From: Laura Gibbons <Laura.Gibbons@arun.gov.uk>
Sent: 21 December 2021 15:11
To: Planning.Responses <Planning.Responses@arun.gov.uk>
Cc: Anita Gardner <Anita.Gardner@arun.gov.uk>
Subject: FW: Planning Consultation on: CM/72/21/DOC

Engineers Comments Regarding Condition 10

Application No: CM/72/21/DOC

Site Address: Mistletoe Farm Horsemere Green Lane Climping BN17 5QZ

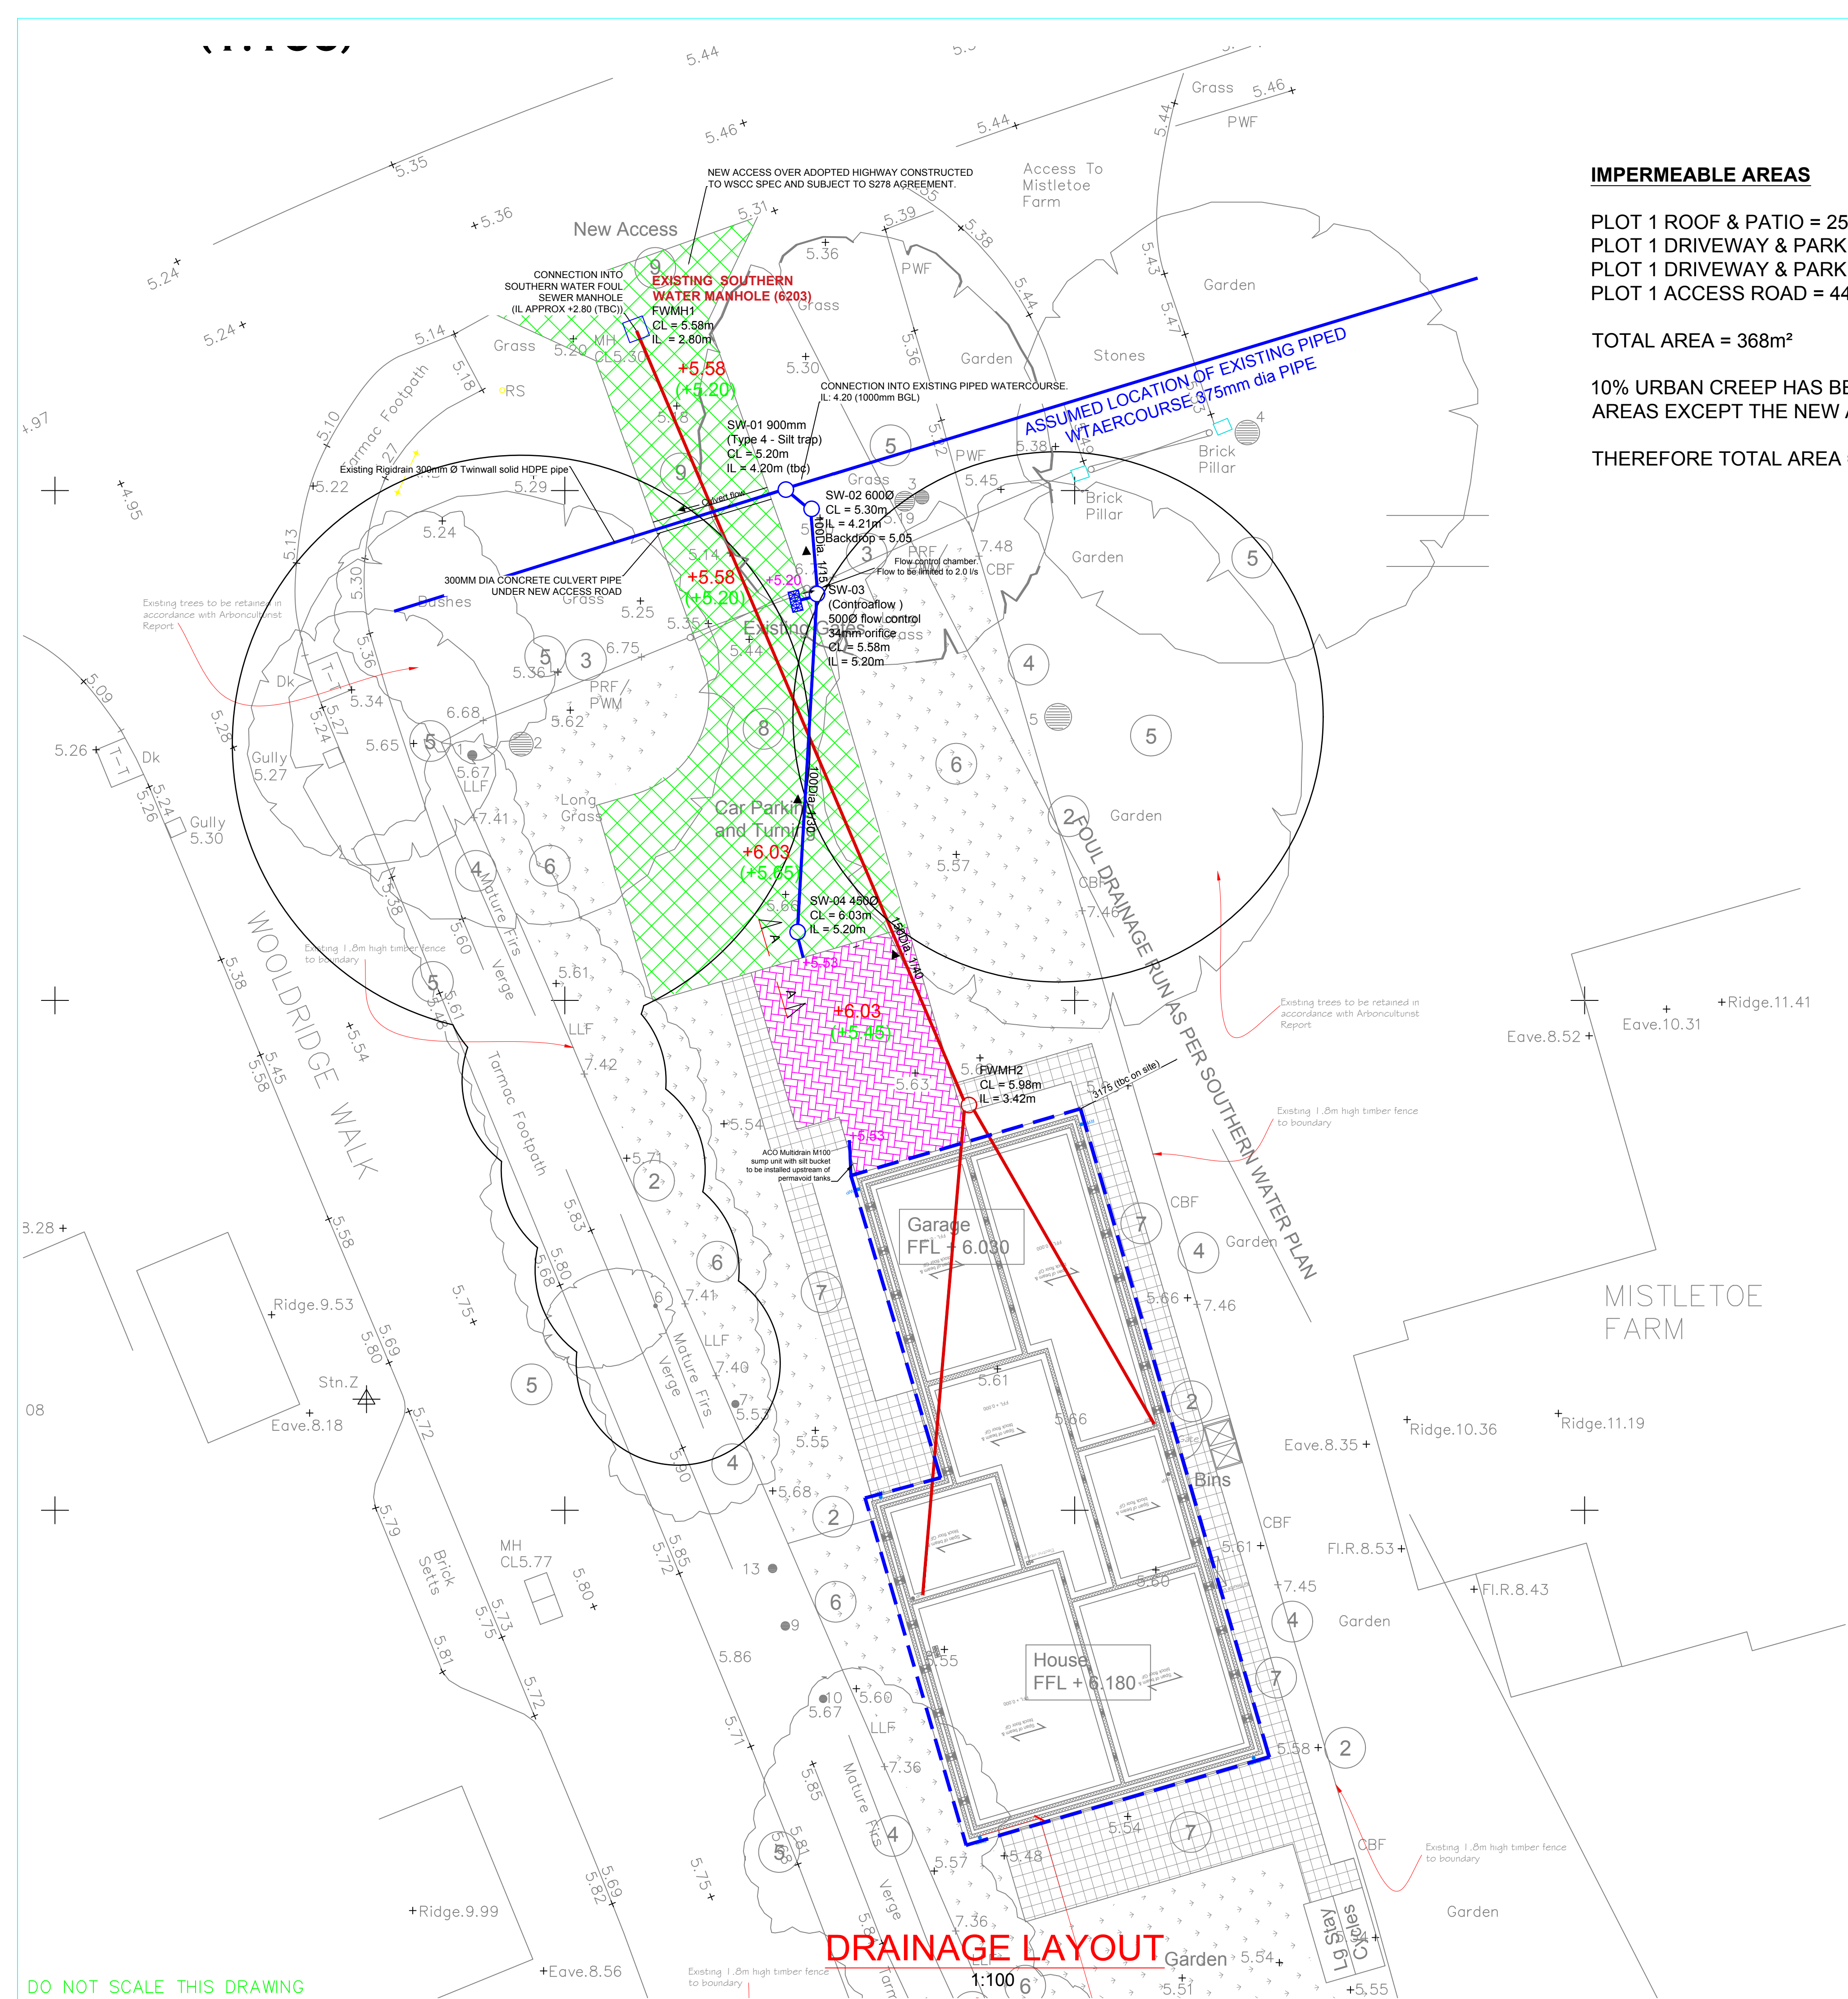
3. Proposals are to attenuate surface water and discharge it to ordinary watercourse at 2l/s. Invert levels of the existing ordinary watercourse culvert should be provided, along with evidence of ordinary watercourse land drainage consent.

4. The access track is proposed to be permeable, and appears to discharge to the driveway via a diffuser. Please label the invert of the diffuser.
5. It is not clear how water from the access will be discharged into the driveway. Is it proposed to discharge via a diffuser, a permeable pipe, rigid pipe? Please provide clarity on layout, and provide a construction detail drawing.

6. It is not clear how water will be collected from the driveway. Is it proposed to collect via a diffuser, a permeable pipe, rigid pipe? Please provide clarity on layout, and provide a construction detail drawing.
7. There appears to be a rogue diffuser unit on the layout plan, this is not connected. Please remove.
8. Catchpits must be provided upstream of connections into permeable paving.
9. Please label all pipes with diameter and fall.
10. Please provide construction detail drawings of catchpits, pipe bed and surround, and hydrobrake.
11. Calculations do not demonstrate the required head specification for the hydrobrake.
12. Calculations do not appear to account for the fact that the access track will discharge into the driveway.

(SECTION A-A) - SECTION THROUGH JUNCTION BETWEEN PERMEABLE ACCESS ROAD / DRIVEWAY AREAS (WITHIN RPA) AND PERMEABLE DRIVEWAY WITH PERMAVOID SUB-BASE REPLACEMENT ATTENUATION SYSTEM
SCALE 1: 15

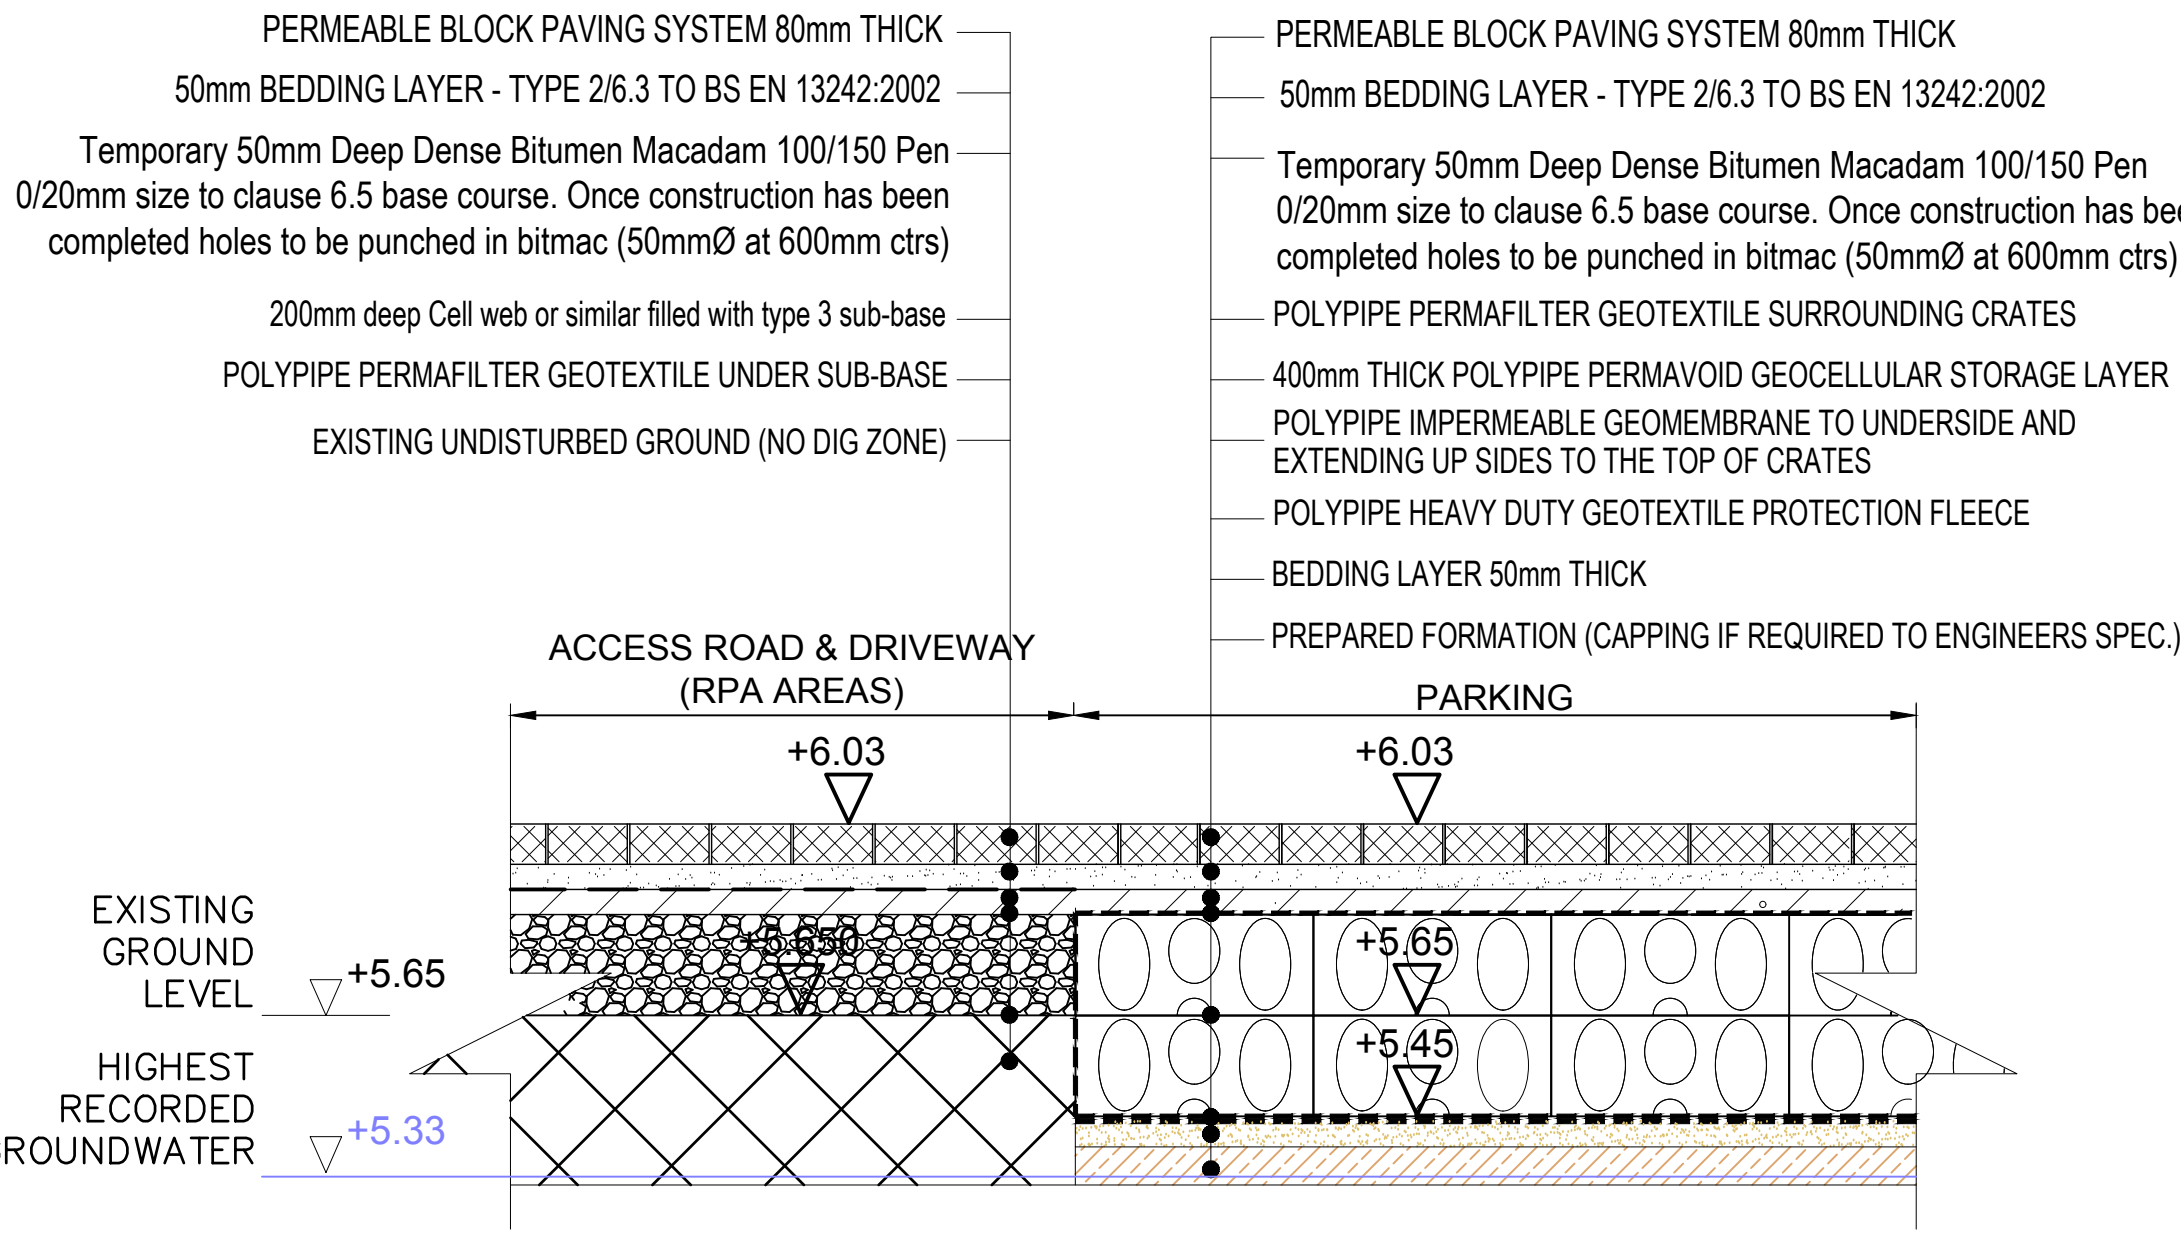
2. Section A-A states a highest recorded groundwater level of 5.33mAOD. This is 700mm below ground level, which is significantly lower than adjacent sites. Please provide winter groundwater monitoring results.
